Application Reference: 2025/0319

Location: 12 Guildford Road, Royston, Barnsley, S71 4HU.

This application seeks planning permission for the erection of a two-storey side extension.

S71 4HU - 2

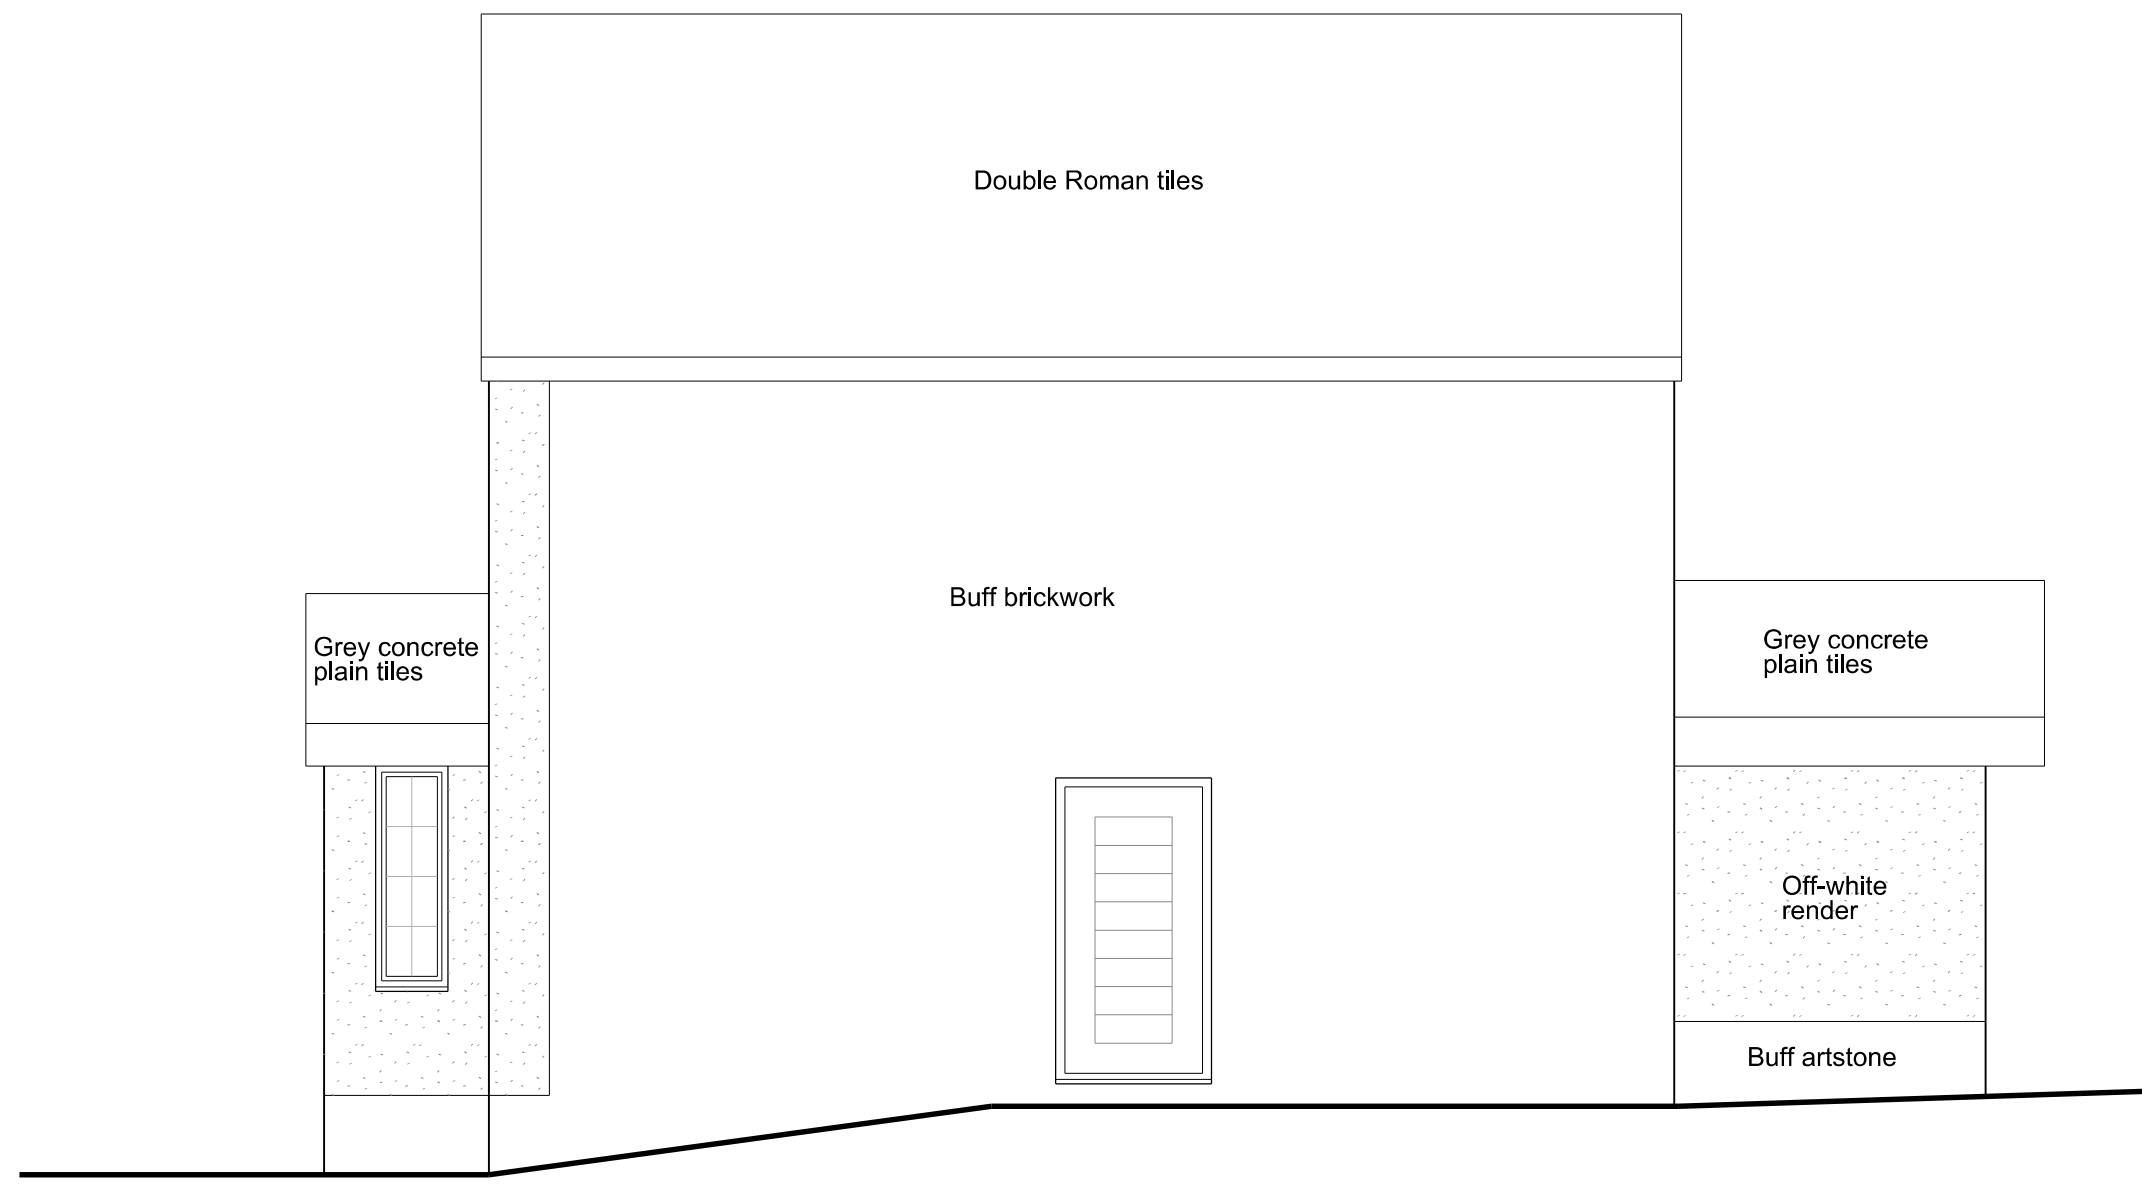
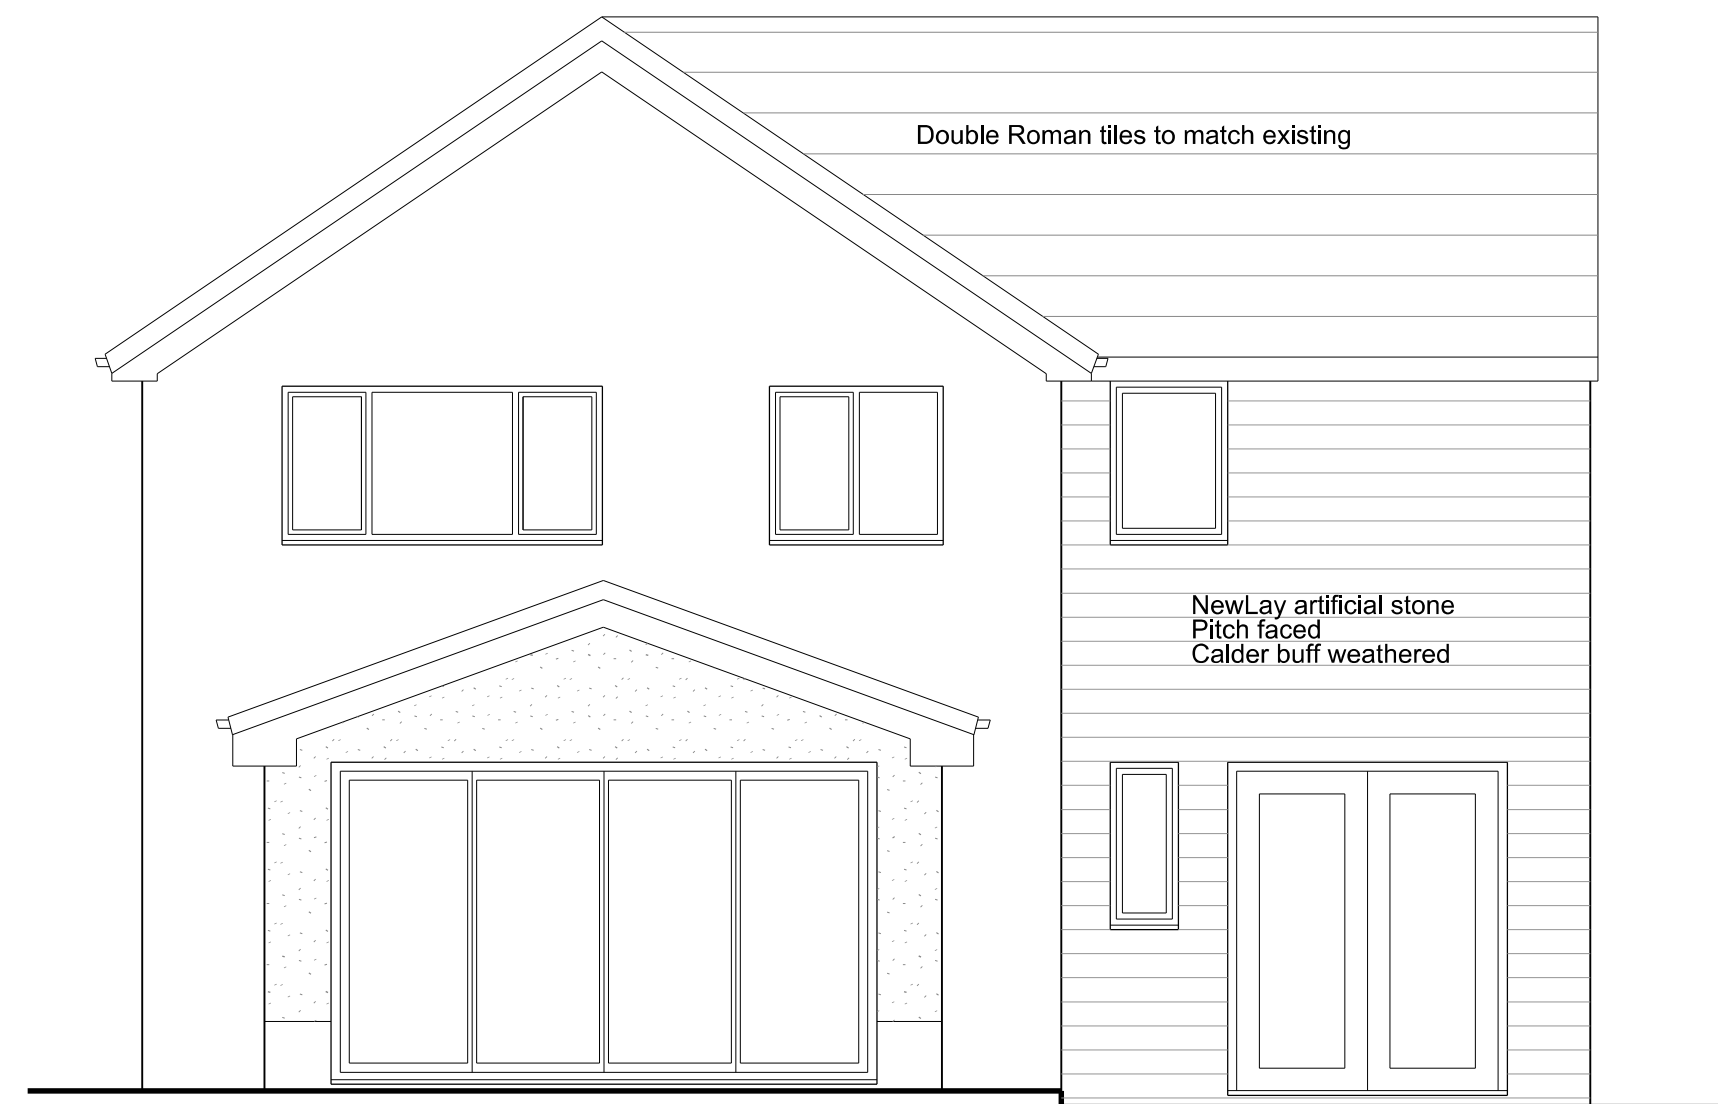
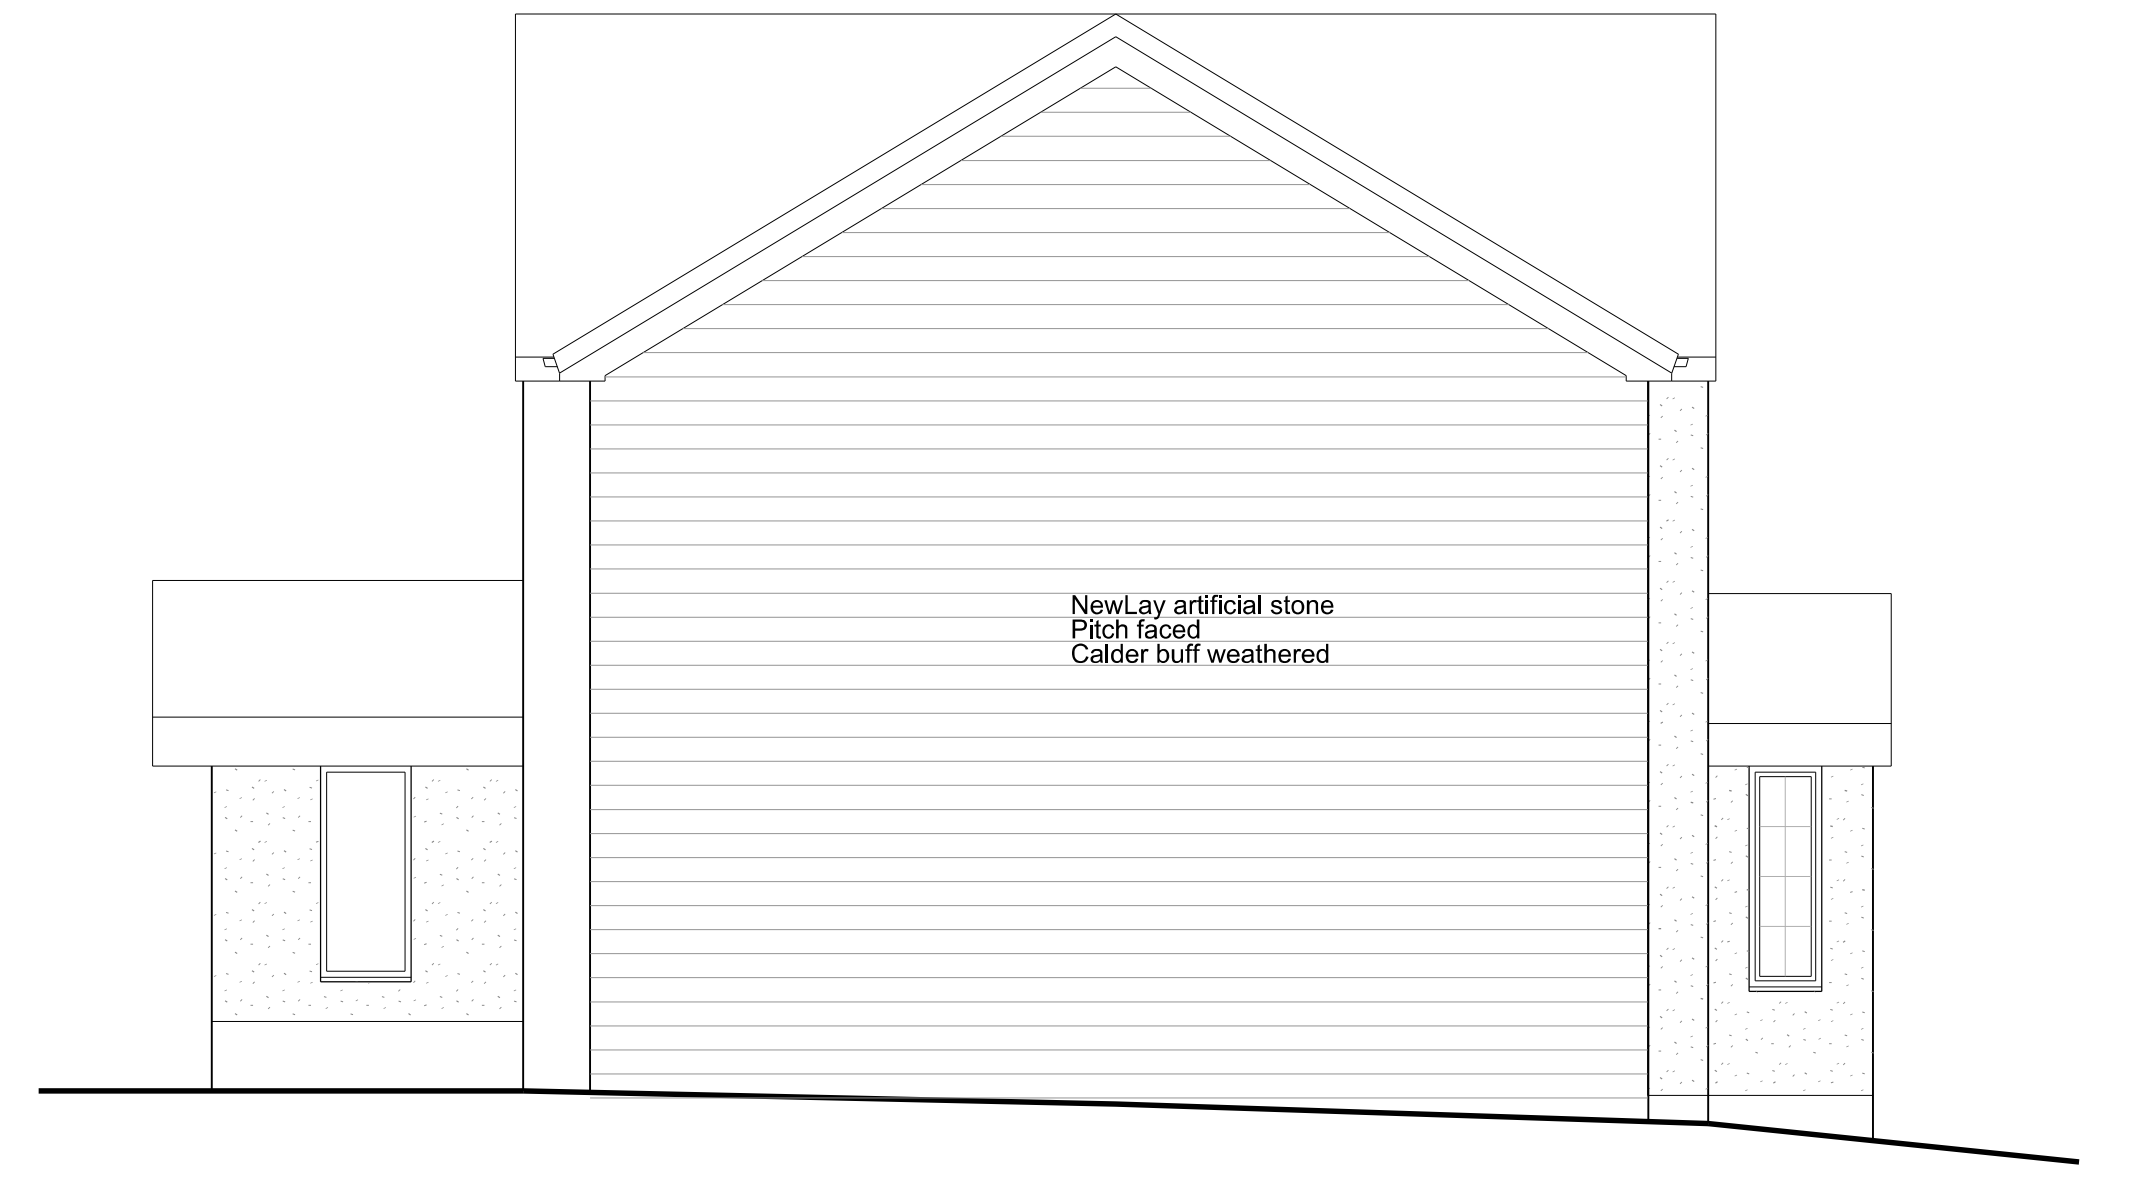
In this instance, the proposed extension would adopt a pitched roof and would be set back from the front and rear elevations of the original dwelling by approximately 0.4 metres. It would be set in from the side boundary by approximately 1.7 metres and it would adopt a sideways projection that would not exceed two thirds the width of the original dwelling. The proposed extension would adopt a width greater than half the gap between the original dwelling and side boundary. However, the existing gap already exceeded two thirds the width of the original dwelling and therefore, the proposal is compliant in this instance. The extension would be constructed of sympathetic external materials, and existing boundary treatments, and topography differences would provide some screening benefit and likely lessen the prominence of the extension within the street scene.
